9 February 2018

Your Ref :
Our Ref : AL/114/17/NMA

Section 96A of the Town & Country Planning Act 1990 (as amended)
Town and Country Planning (Development Management Procedure) (England) Order 2015 (as amended) - Article 10
Application for a non- material amendment following the grant of AL/25/12/ for amendment to roof design & fenestrations.
Holly Cottage, 27A Belle Meade Close, Woodgate, Aldingbourne

PROPOSED ELEVATIONS

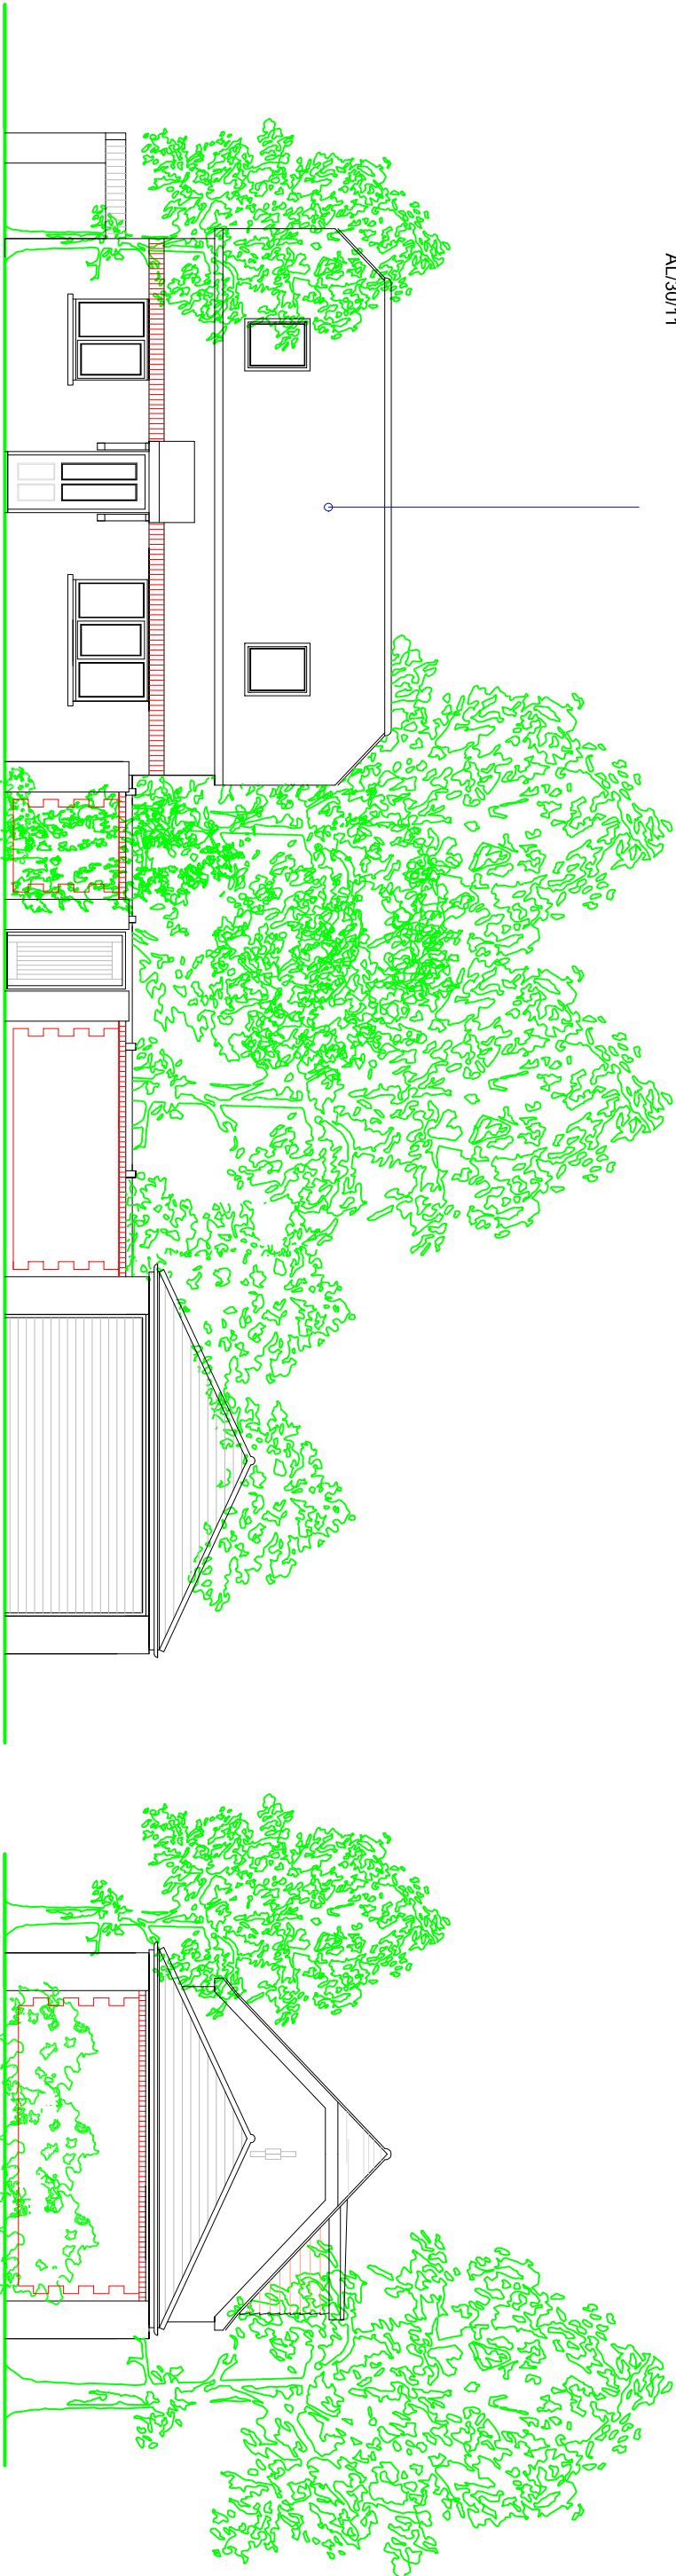
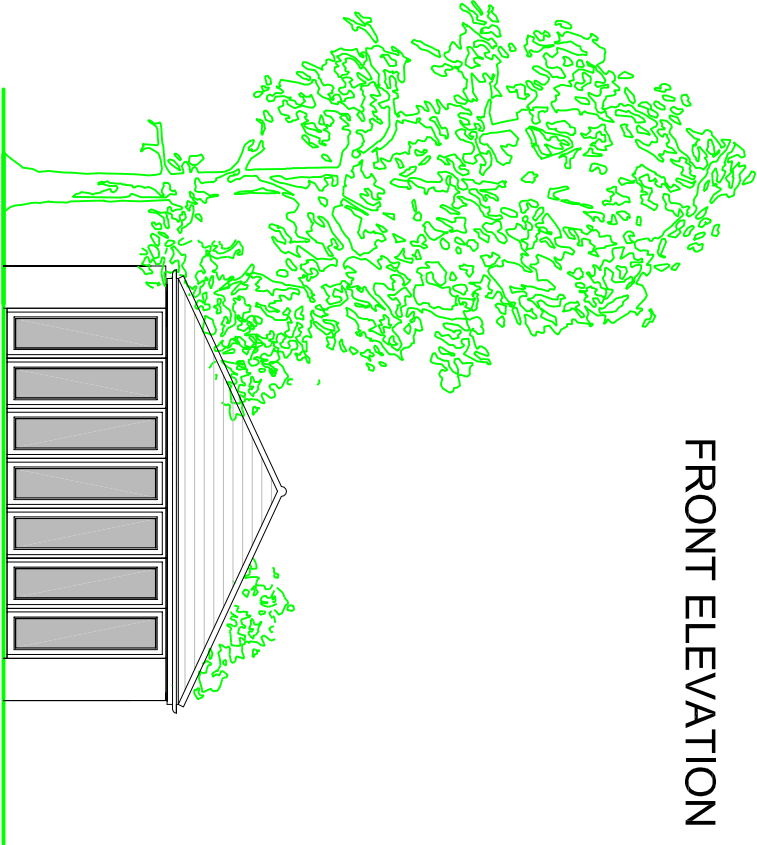
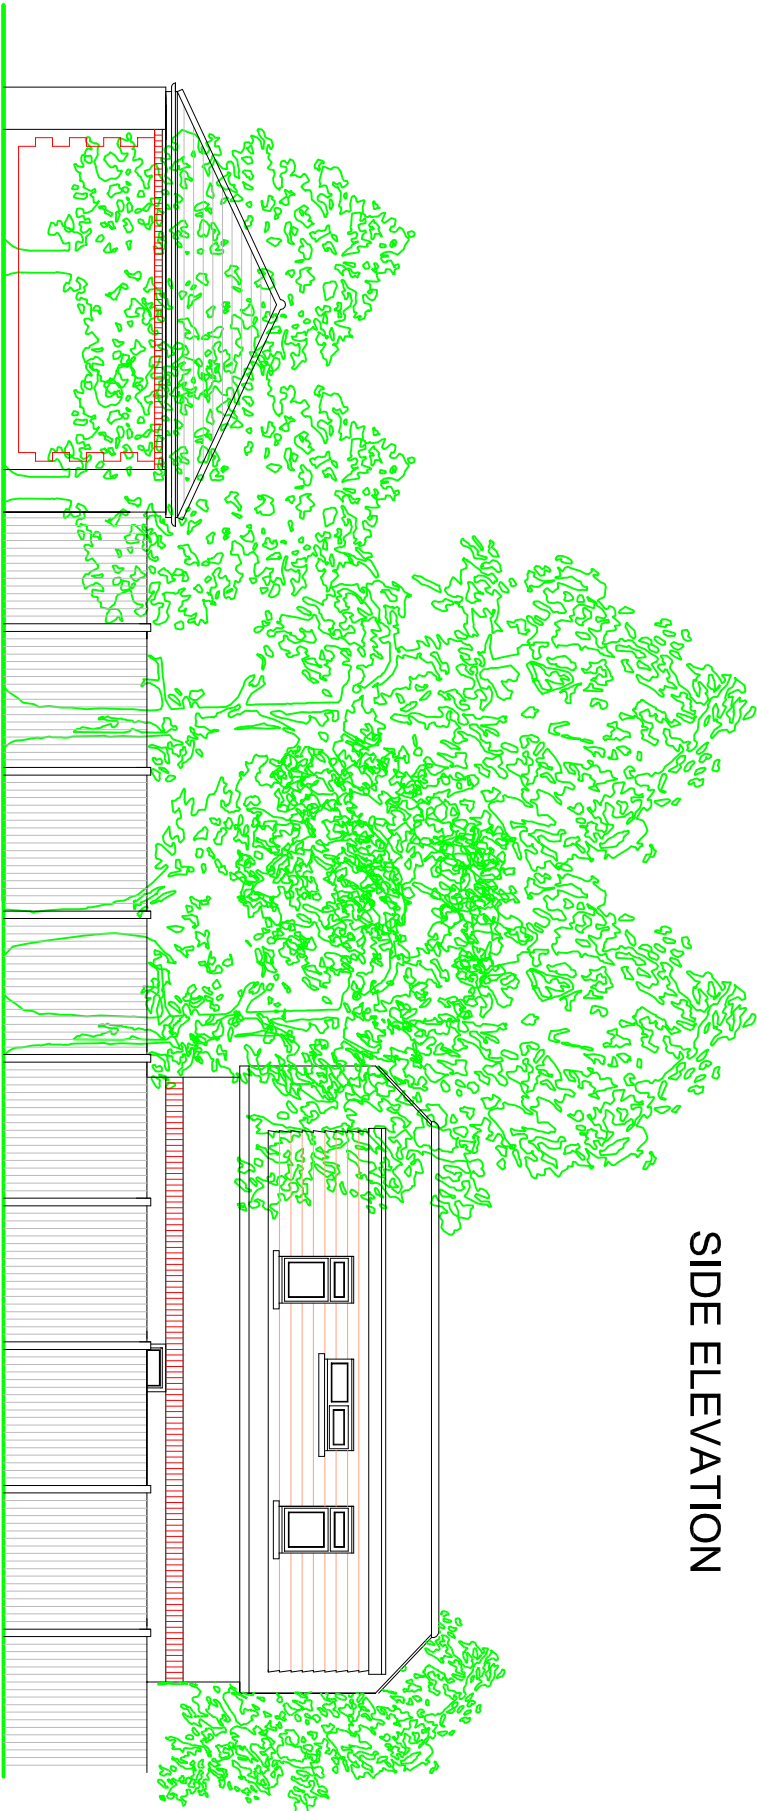
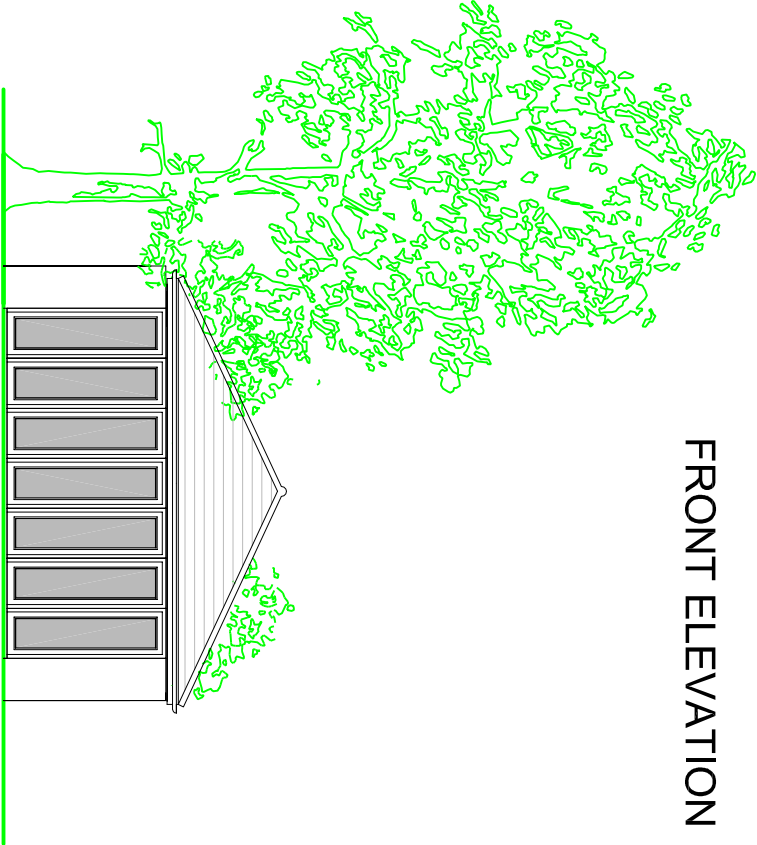
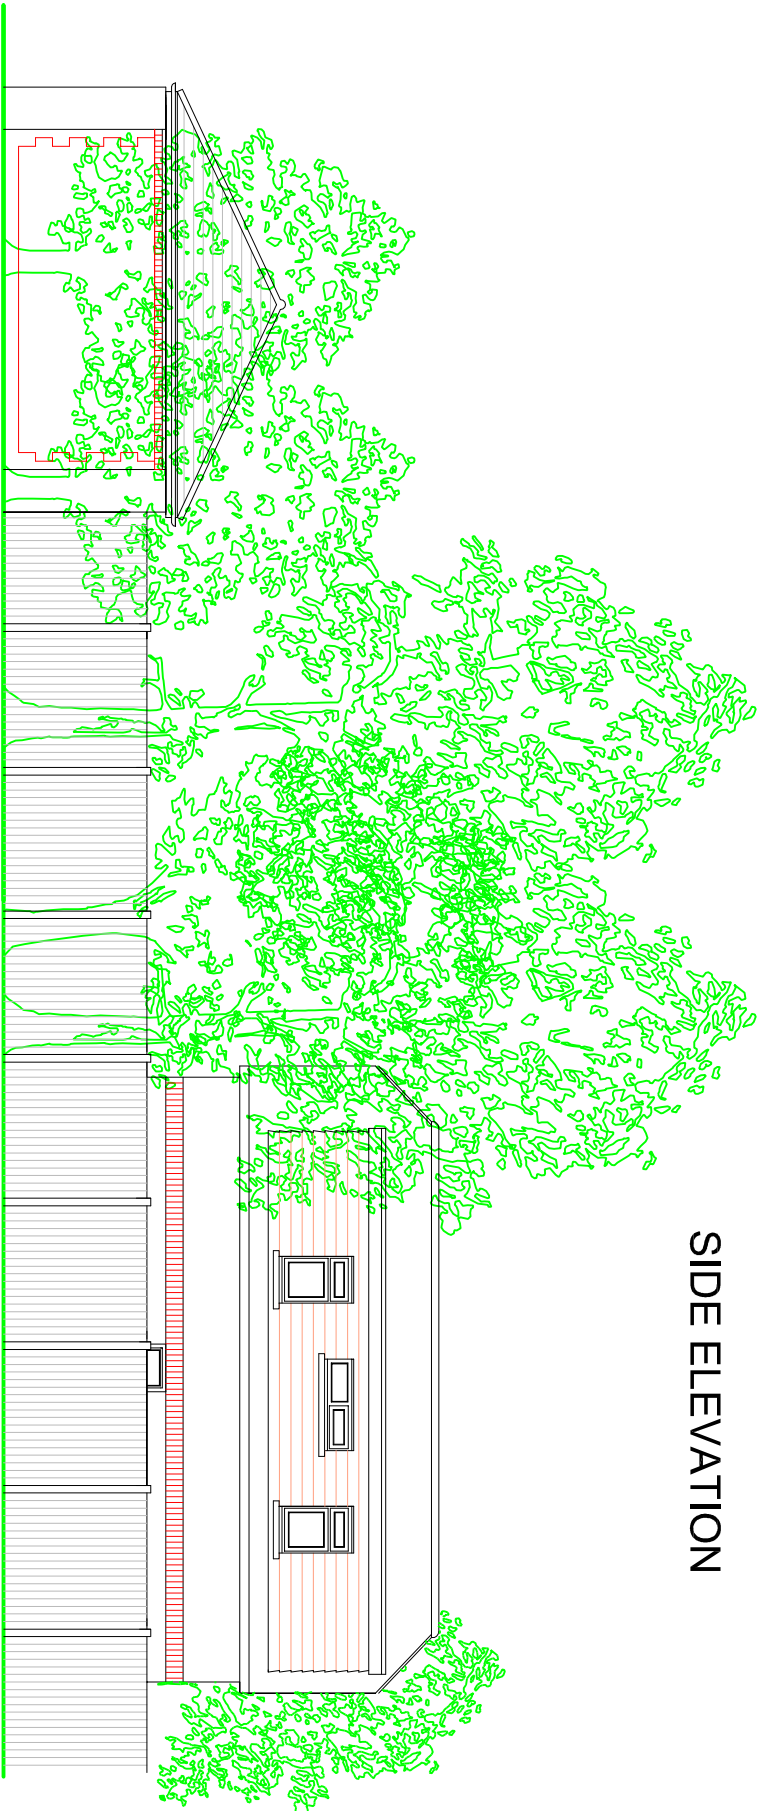
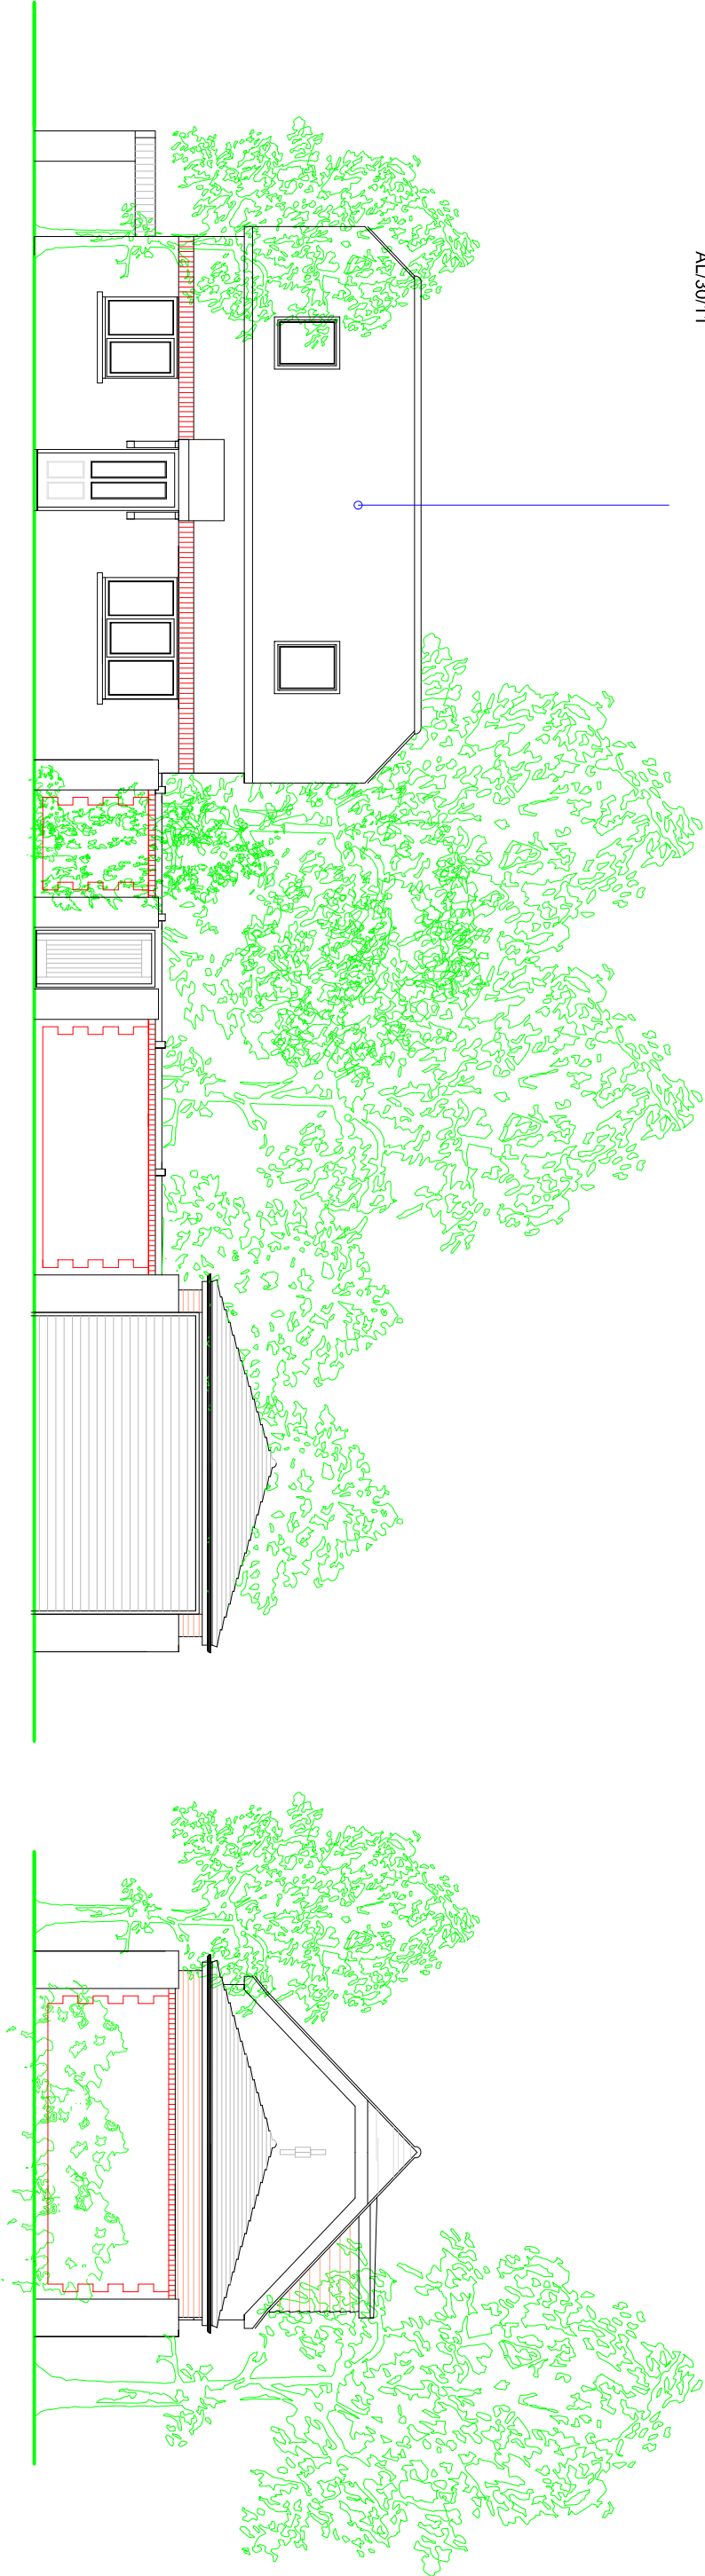
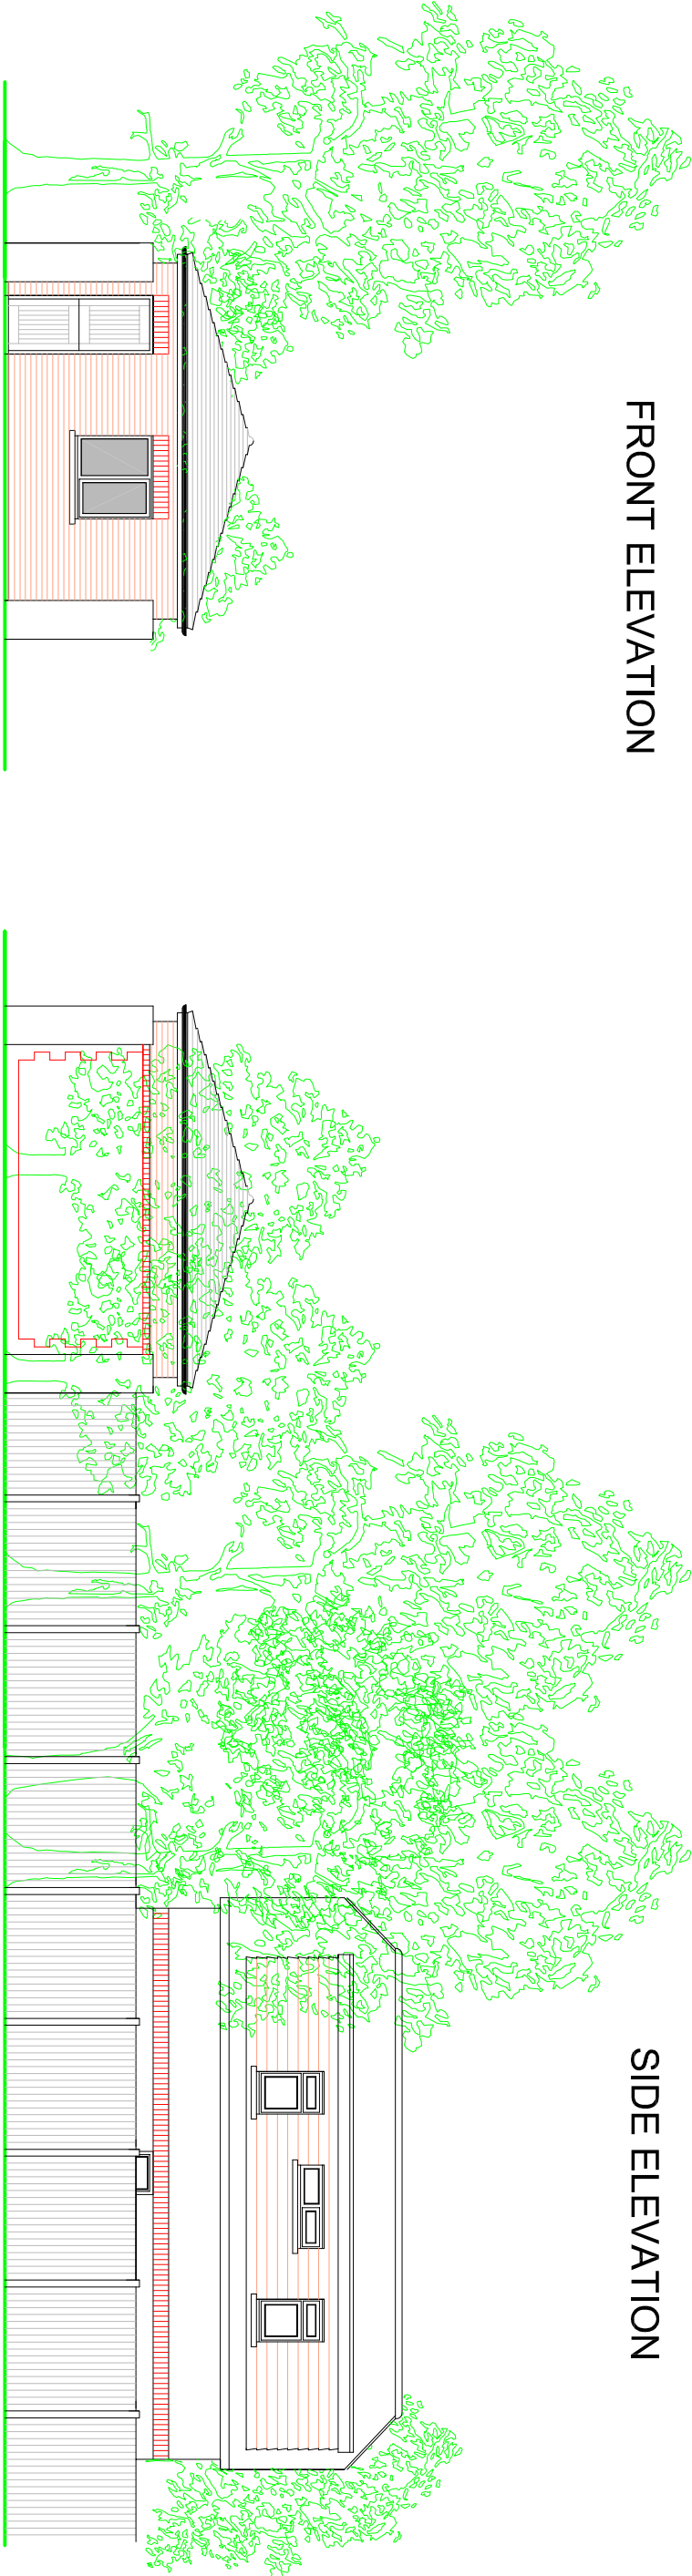
I refer to your recent application for a Non Material Minor Amendment. I note that you propose to reduce the eaves height of the existing detached garage roof by approximately 0.25m (whilst retaining the ridge height at 3.5m) and alter the fenestration to the side elevation onto the garden from a door & window to a set of folding glazed doors with fixed side lights

Please note that the Drawing "Proposed Elevations" Rev D (06/10/17) now replaces "Proposed Elevations" Rev B (15/05/12) from the AL/25/12/ permission.
